RE: **File/Gul Development**
Grading and Drainage Plan
Engineer's Stamp Date 10/18/17
Hydrology File: G13D033

Based on the information provided in your submittal received 10/18/17, the Grading and Drainage Plan cannot be approved for Building Permit until the following comments are addressed.

Grading and Drainage Plan

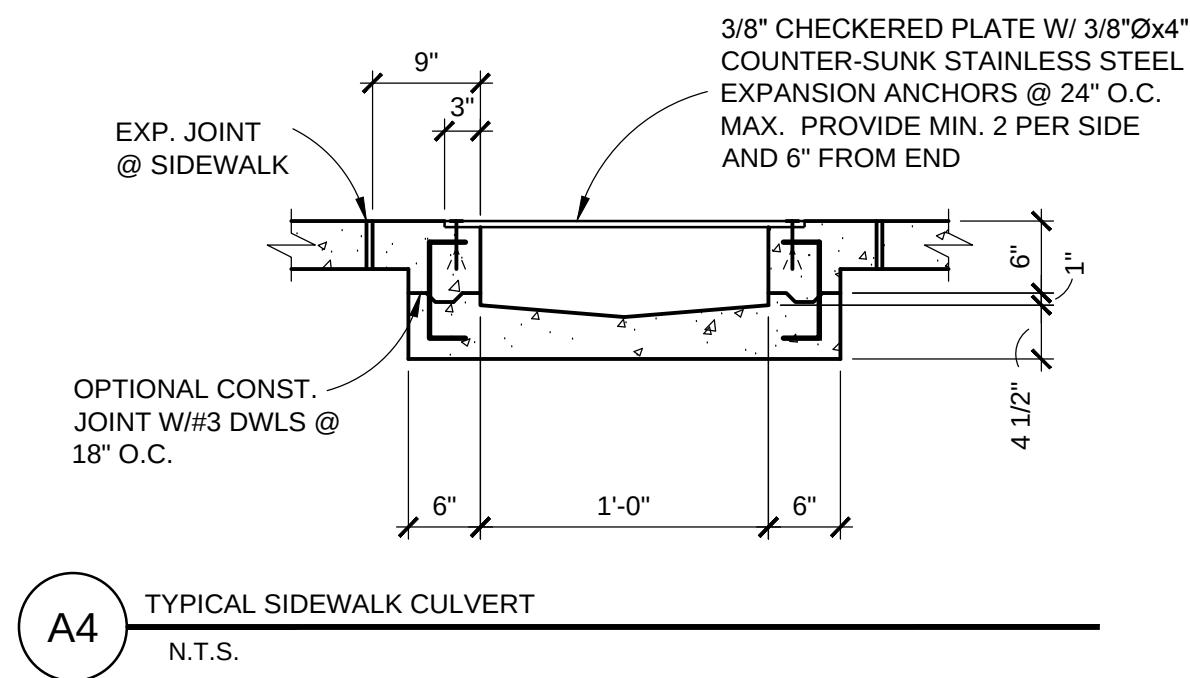
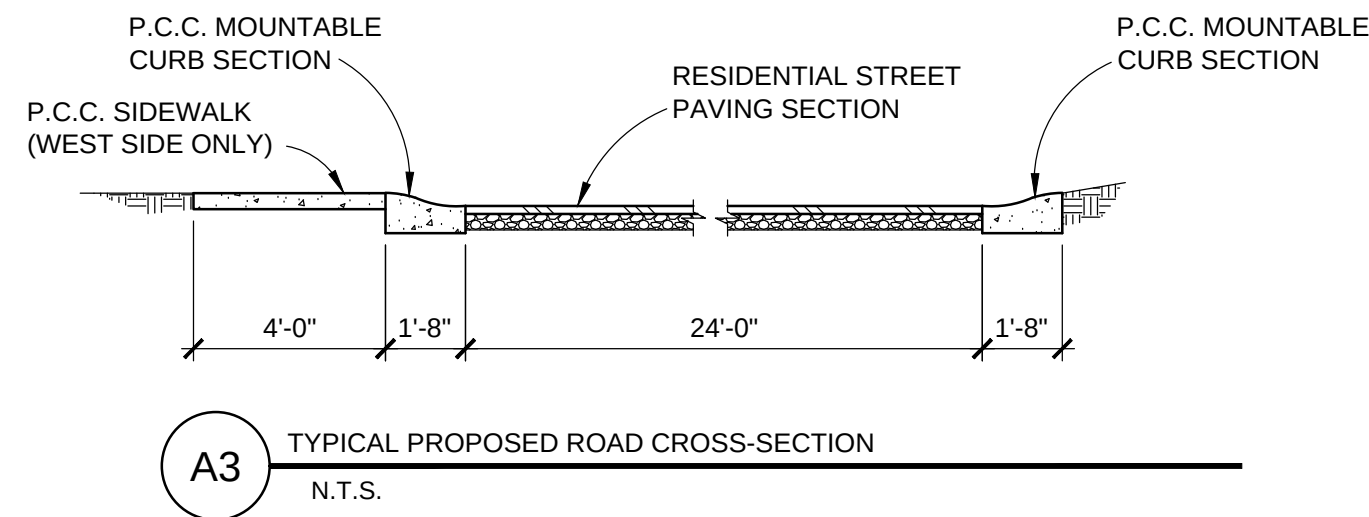
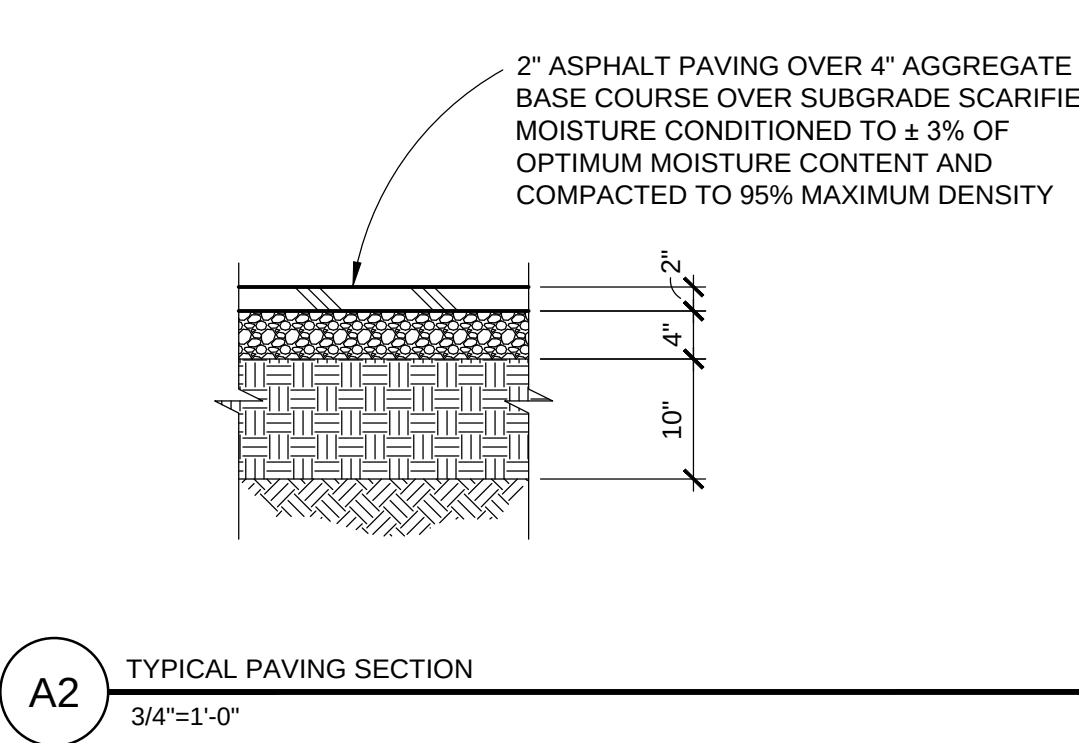
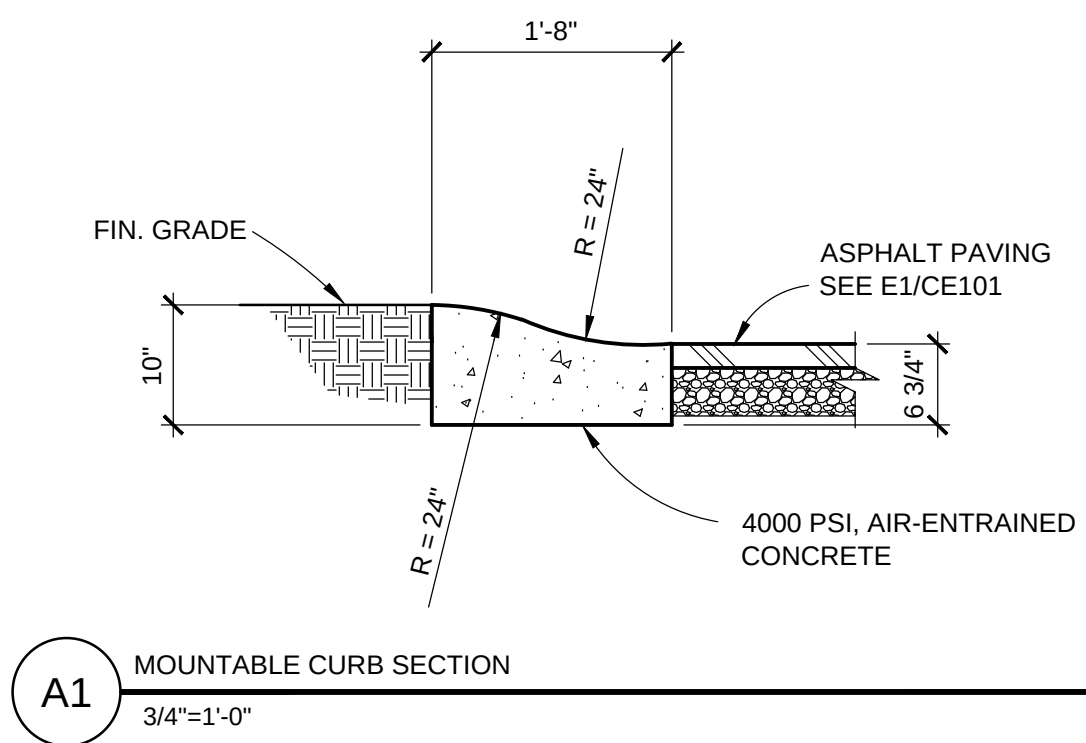
2. On-site retention of the developed 10-day, 100-yr volume is required. This site does not currently drain to Matthew and any discharge to the public ROW on Matthew or otherwise will require demonstration of downstream capacity in accordance with § 14-5-2-12 (G) of the Albuquerque Code of Ordinances.

3. Ponding needs to be located where runoff can reach it. Include a subbasin map showing the drainage basins for each pond.
4. It is recommended that finished floors be elevated 1' (min) above top of pond.

5. The new private drive entrance (Std Dwg 2426) needs to include the 0.87' waterblock.
6. Street names in the vicinity map need to be legible.
7. This project requires an ESC Plan, submitted to the Stormwater Quality Engineer (Curtis Cherne PE, ccherne@cabq.gov or 924-3420).
